**WEST SUSSEX COUNTY COUNCIL**  
**COUNTY HIGHWAYS CONSULTATION RESPONSE**

**SUBJECT:** EP/7/18/PL - Demolition of existing buildings and erection of 2 no. dwellings with associated car ports/parking, alterations to existing access and relocation of staircase to flats - Amendment to EP/138/17/PL.

**Land Rear of Beechlands Cottages, Beechlands Close, East Preston, West Sussex, BN16 1JT**

DRAWING TITLE
Proposed Site Plan, Block Plan
and Location Plan

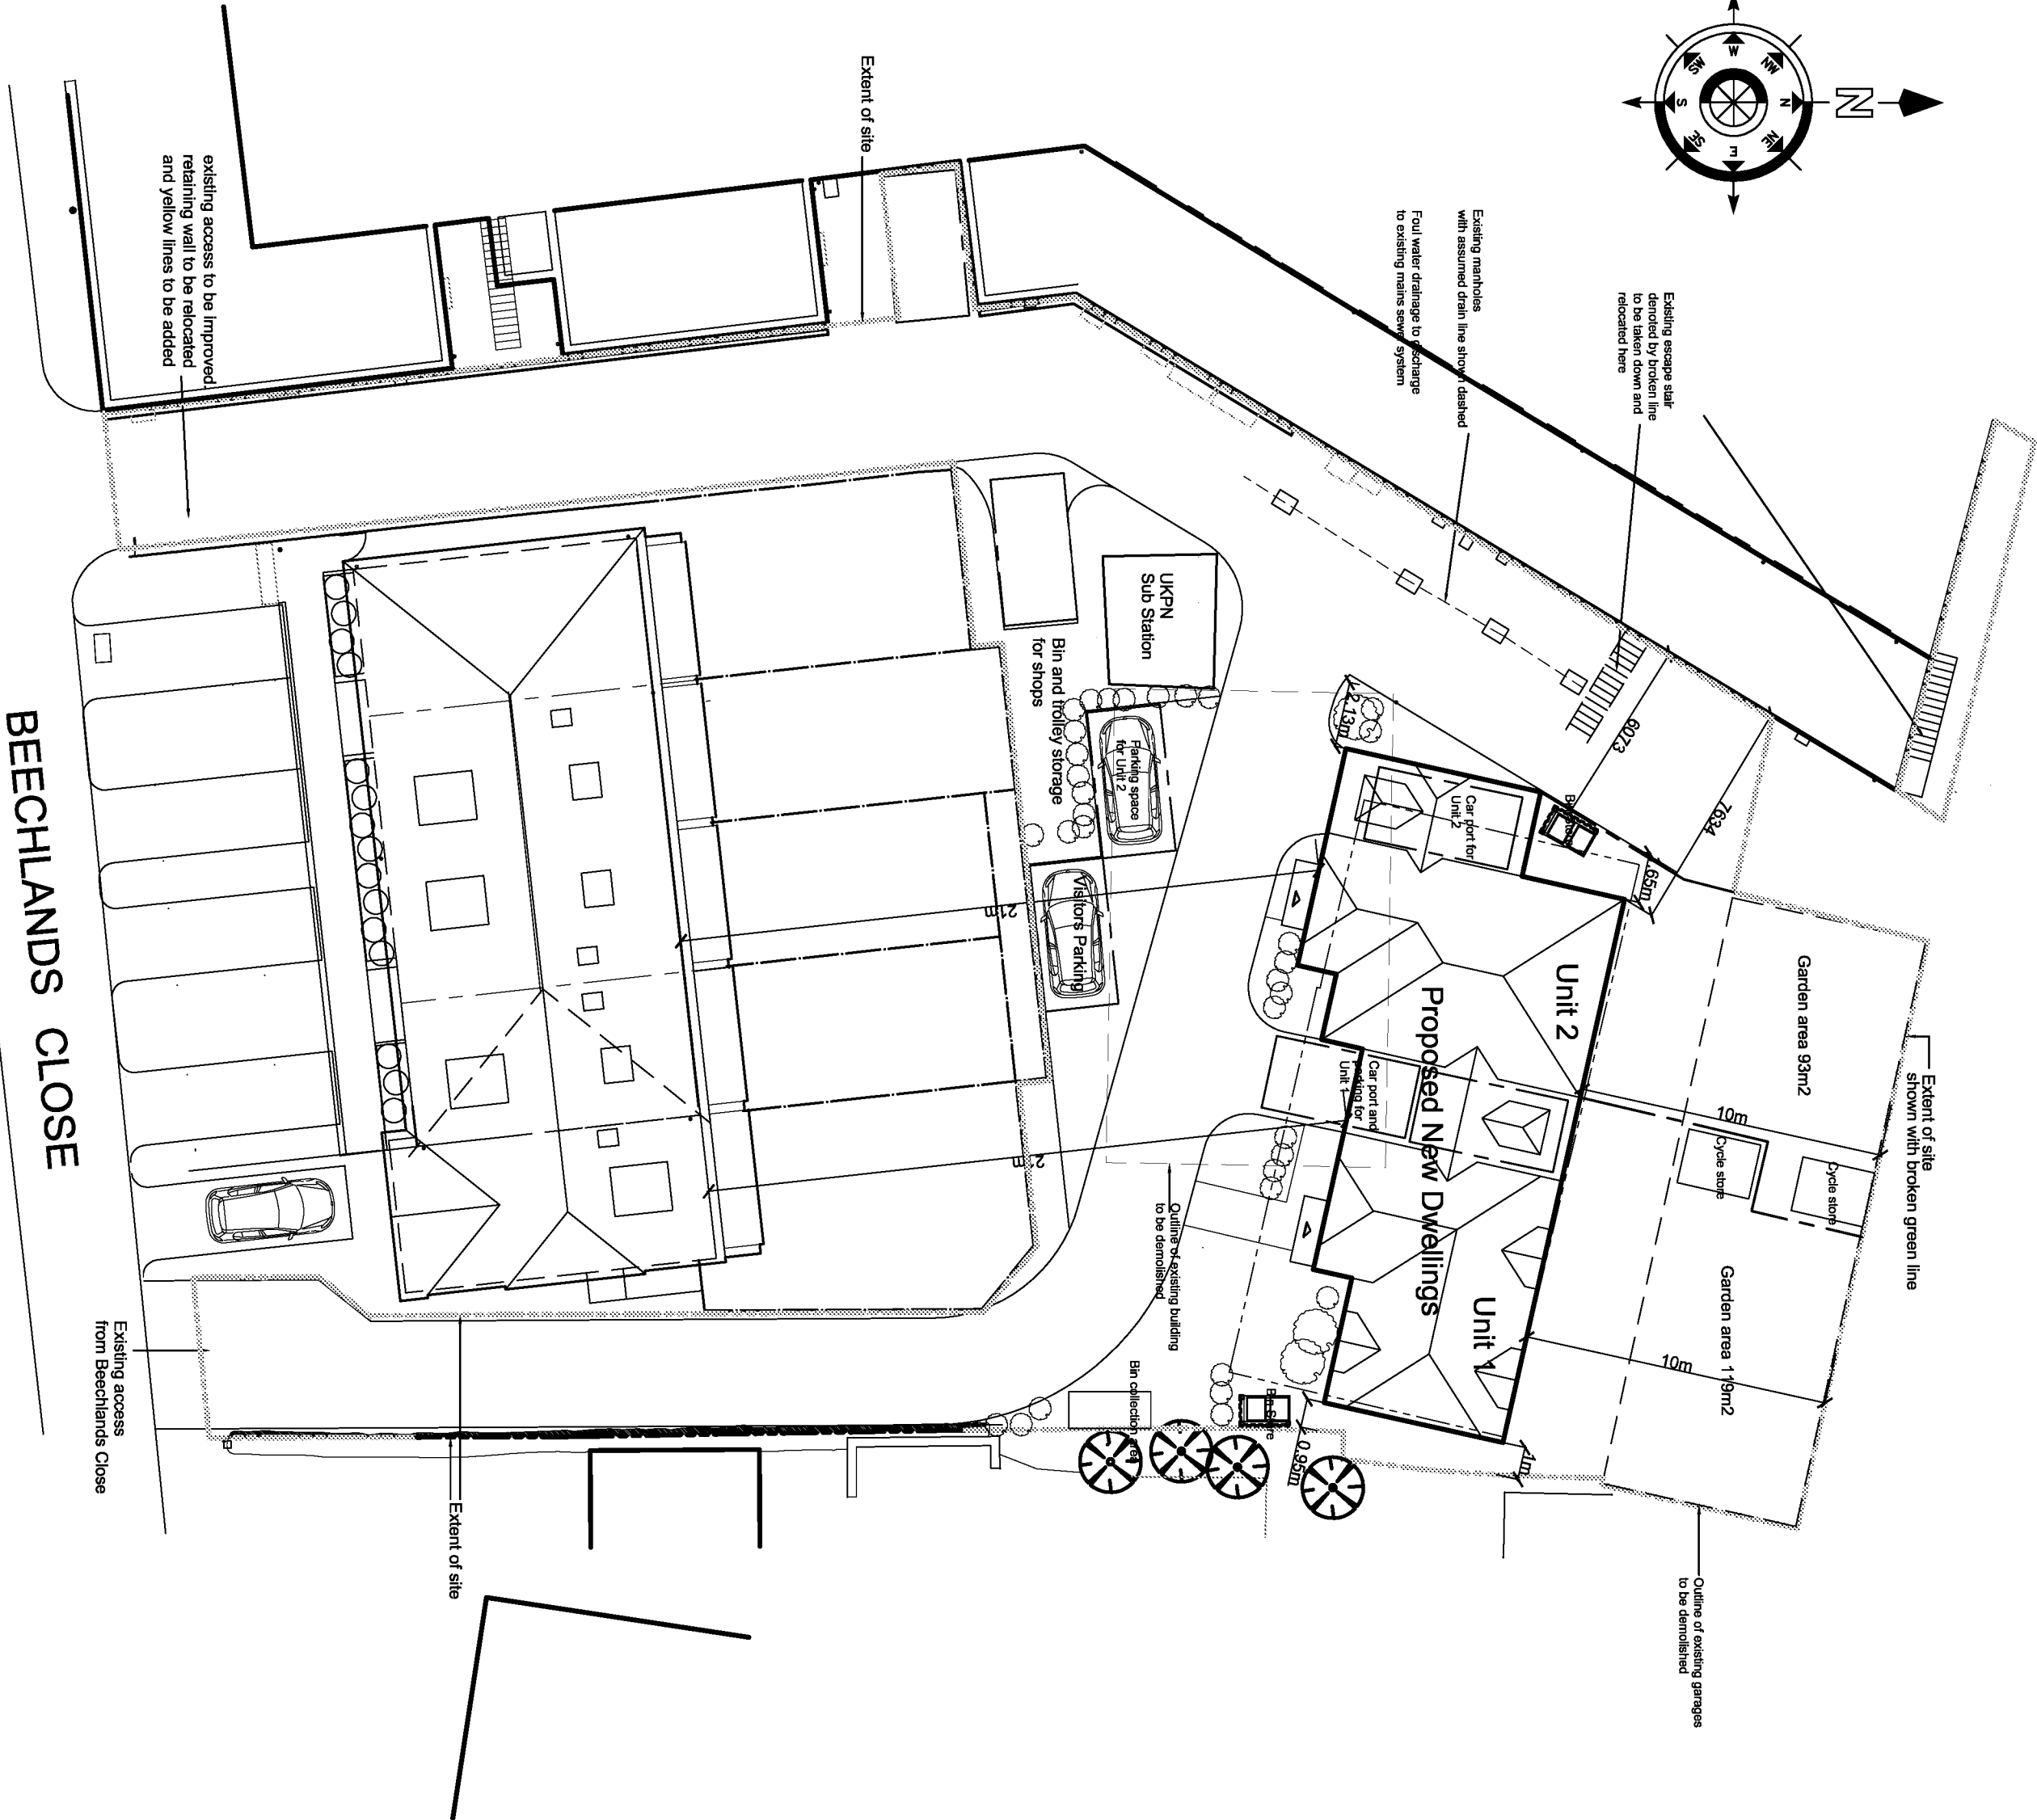
The current resubmission is an amended scheme for 2 x dwellings to the rear of Beechlands Cottages. Unit 2 will be provided with a single car port space plus additional space fronting this. Unit 1 will be provided with an integral car port space plus one allocated on the forecourt area. On this basis of 2 spaces being allocated per dwelling the WSCC Car Parking Demand Calculator envisions a total demand for 5 spaces. An additional visitor parking space is also demonstrated. The LHA are satisfied with the demonstrated amendments in relation to car parking quantity and layout and consider that a turn on site to exit to the public highway in a forward gear is achievable.

The LHA did not raise any highway safety or capacity concerns to the previous application for 3 x dwellings and do not wish to resist the current amended and reduced scale scheme.

No part of the development shall be first occupied until the vehicle parking and turning spaces have been constructed in accordance with the approved plan. These spaces shall thereafter be retained for their designated use.

No part of the development shall be first occupied until covered and secure cycle parking spaces have been provided in accordance with the approved plans.
